Our ref: DOC25/557257-12

EPA Advice on Modification Report – Kurnell Terminal – SSD-5544 MOD-7

I am writing in response to your request for the NSW Environment Protection Authority (EPA) to review the Modification report for the proposed Kurnell terminal (Application SSD-5544-MOD-7) at 2 Solander Street Kurnell.

Construction Noise Contours

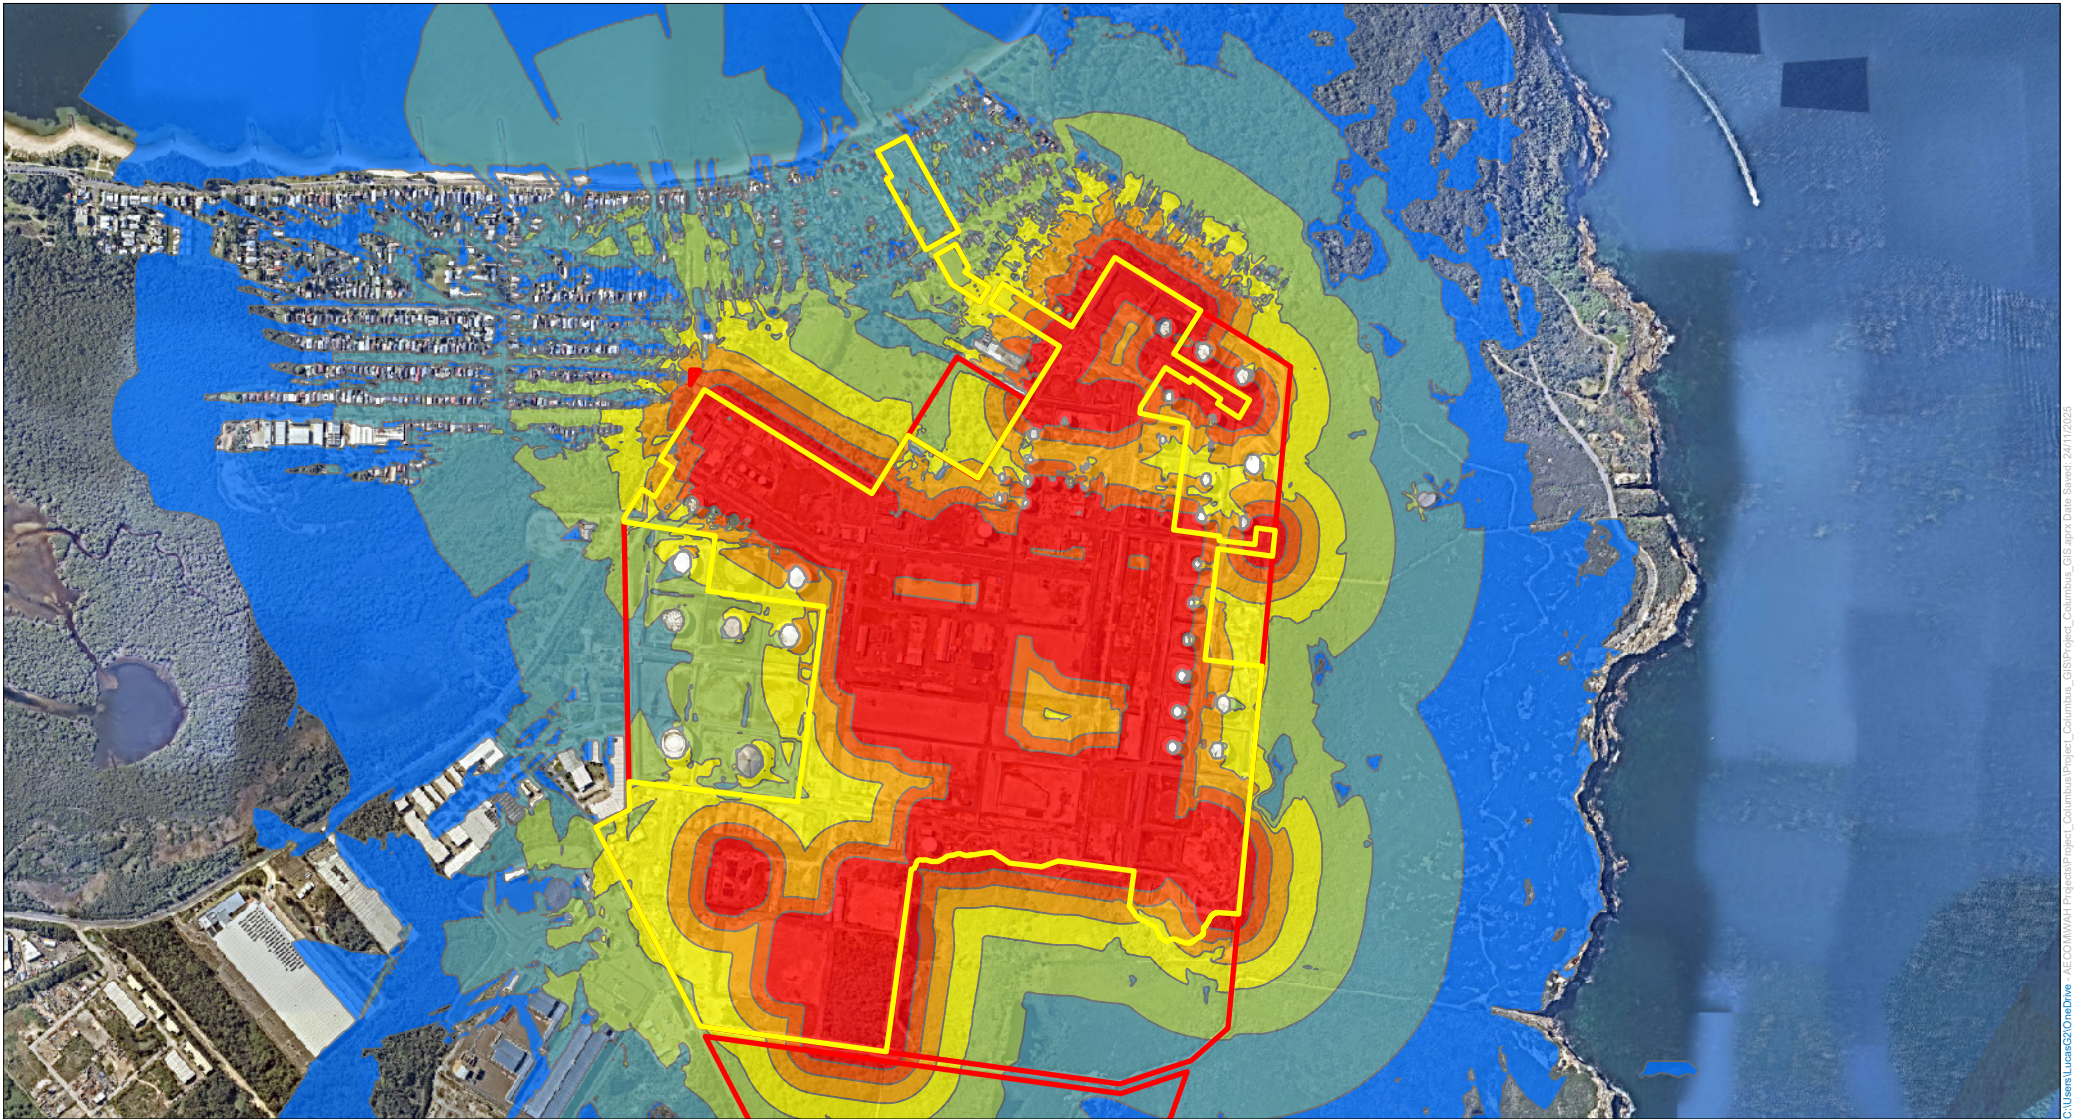
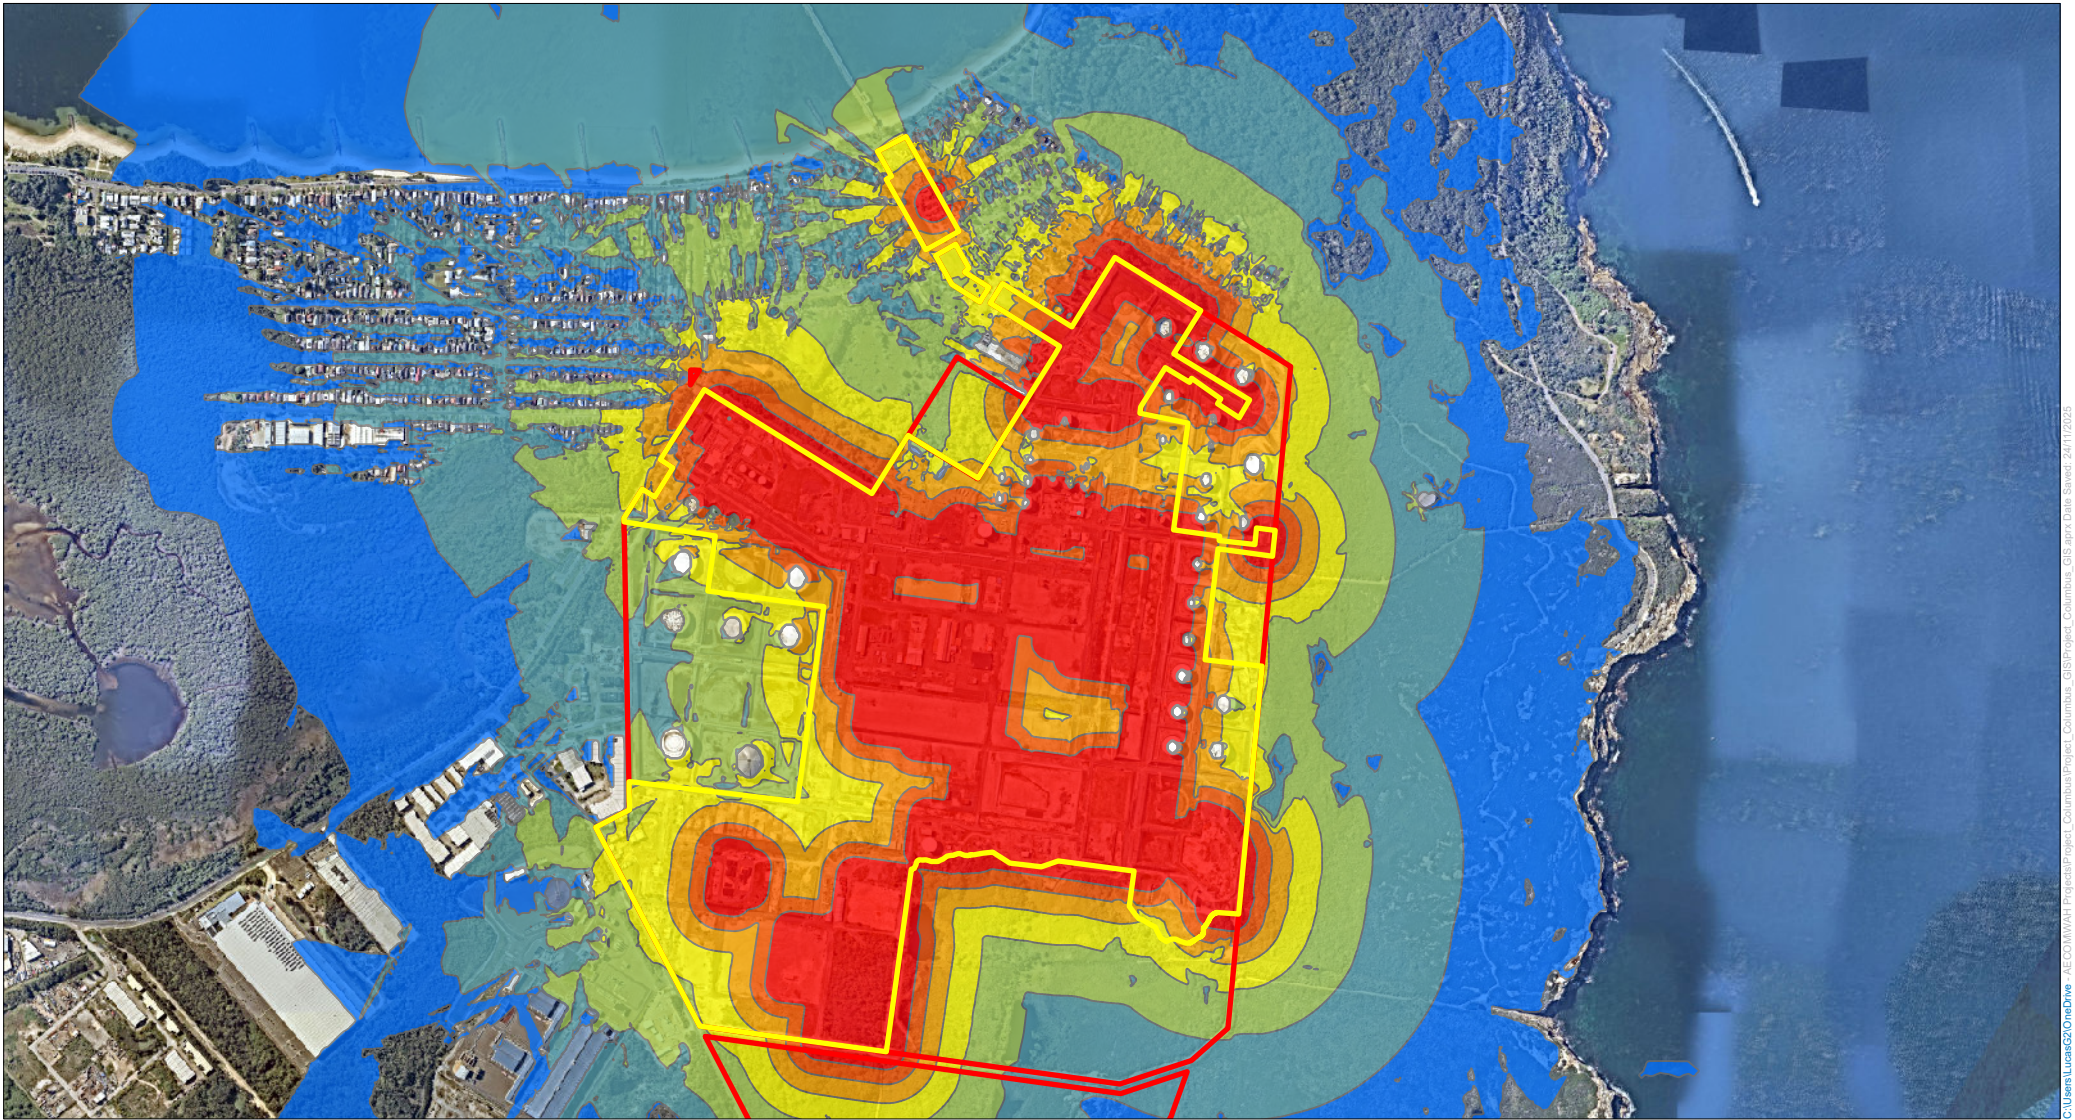
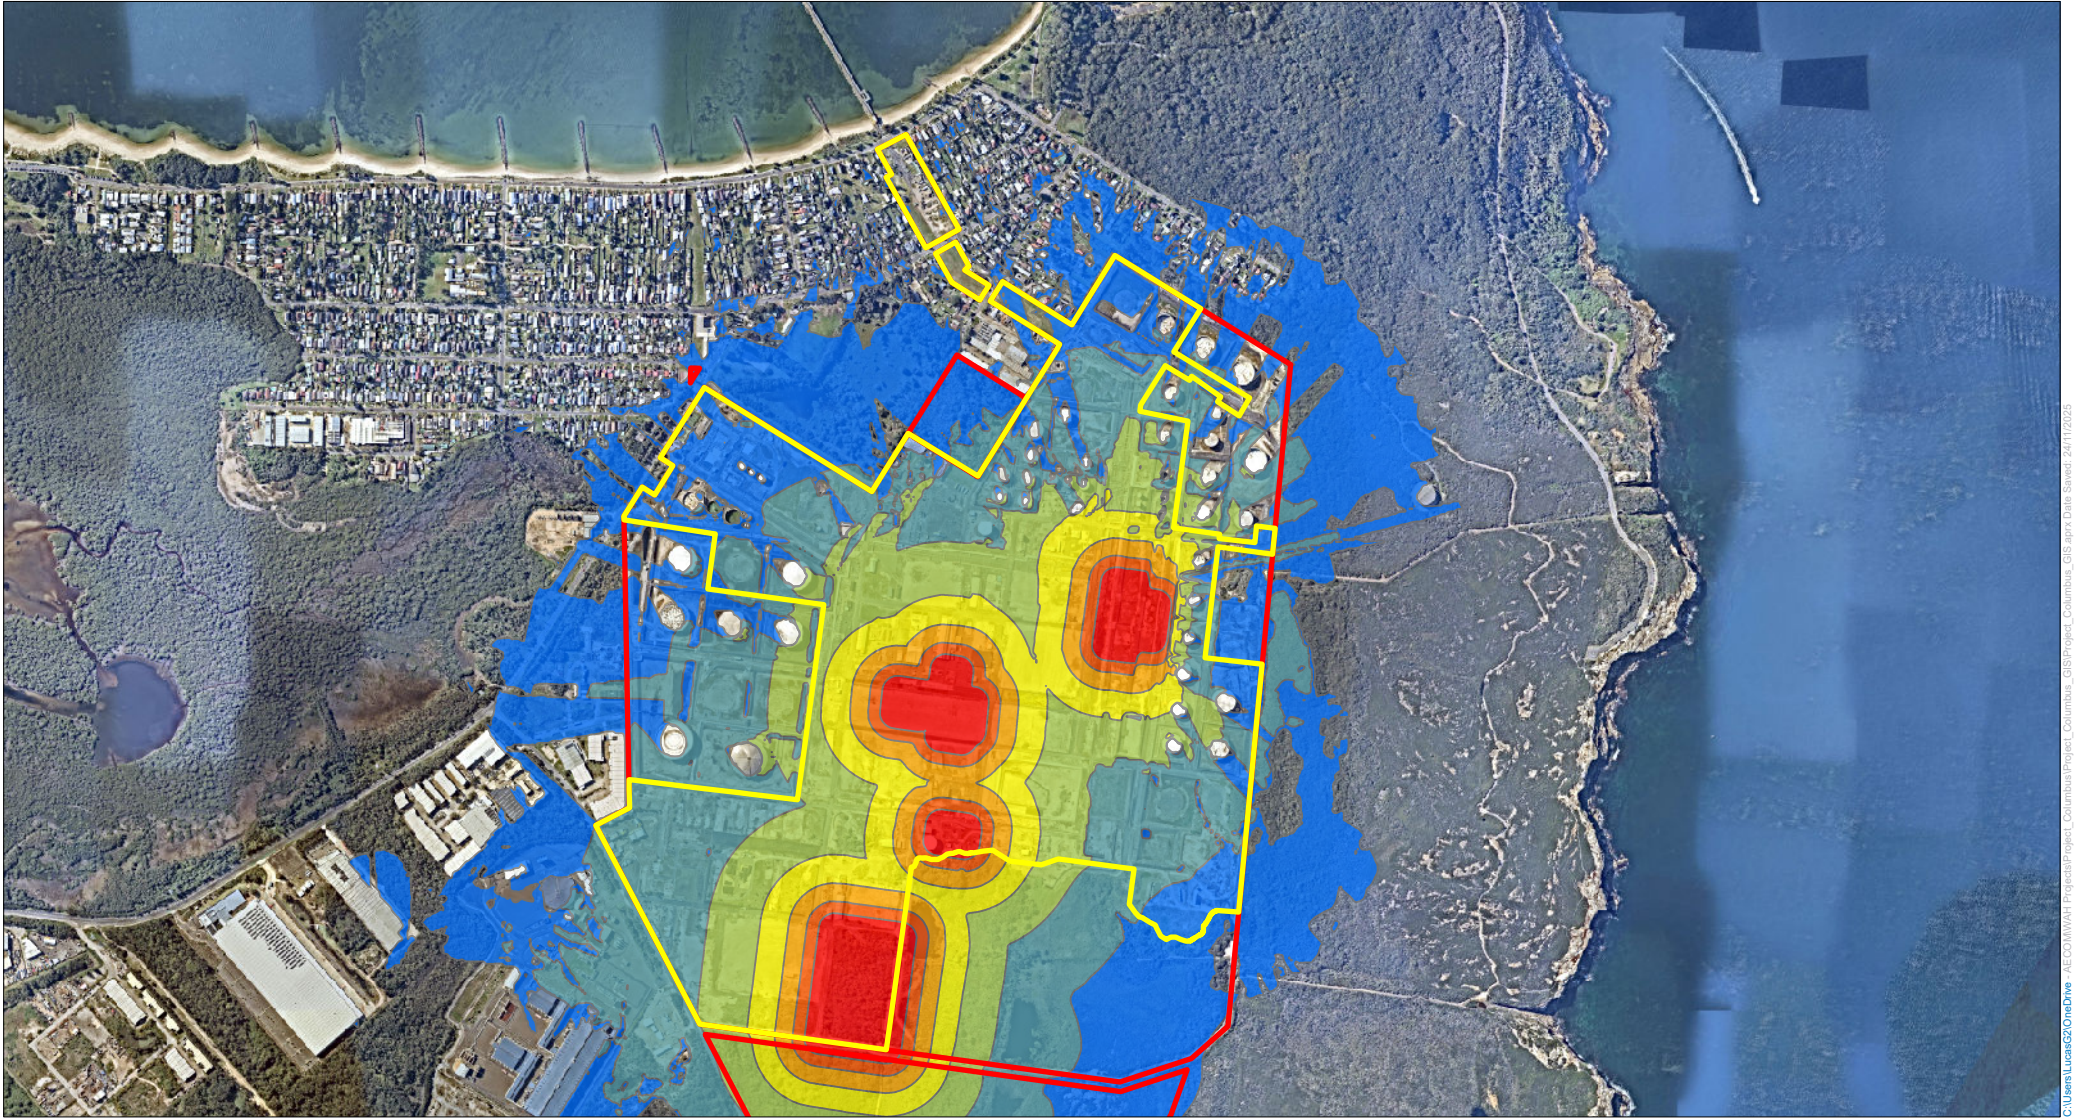
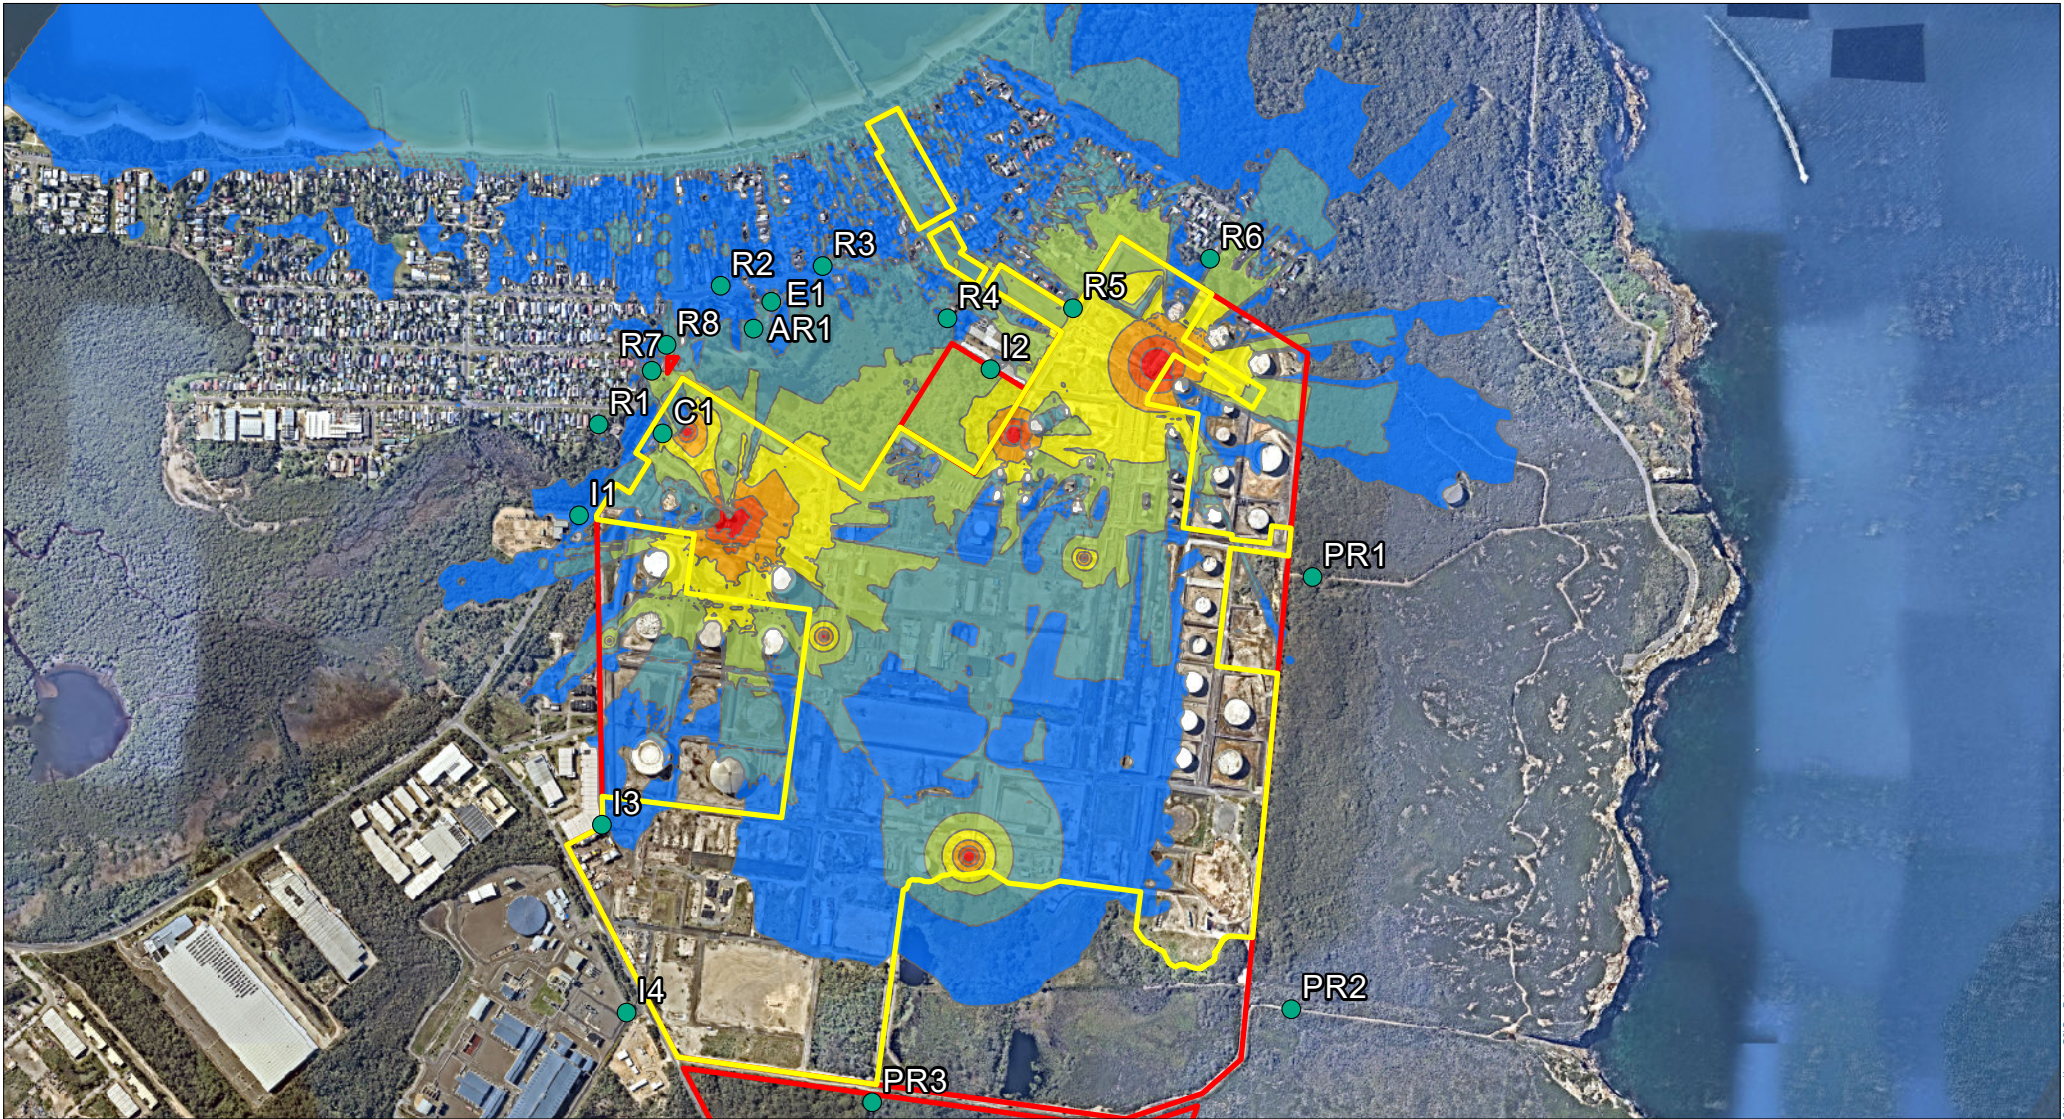
The noise contour maps in Appendix B only show noise levels between 50 and 60 dBA up to 80 dBA. This presentation makes it difficult to understand how noise propagates through the residential areas.

The EPA recommends the operational noise contours are presented to a minimum level of Leq,15min 35 dBA and are provided for review.
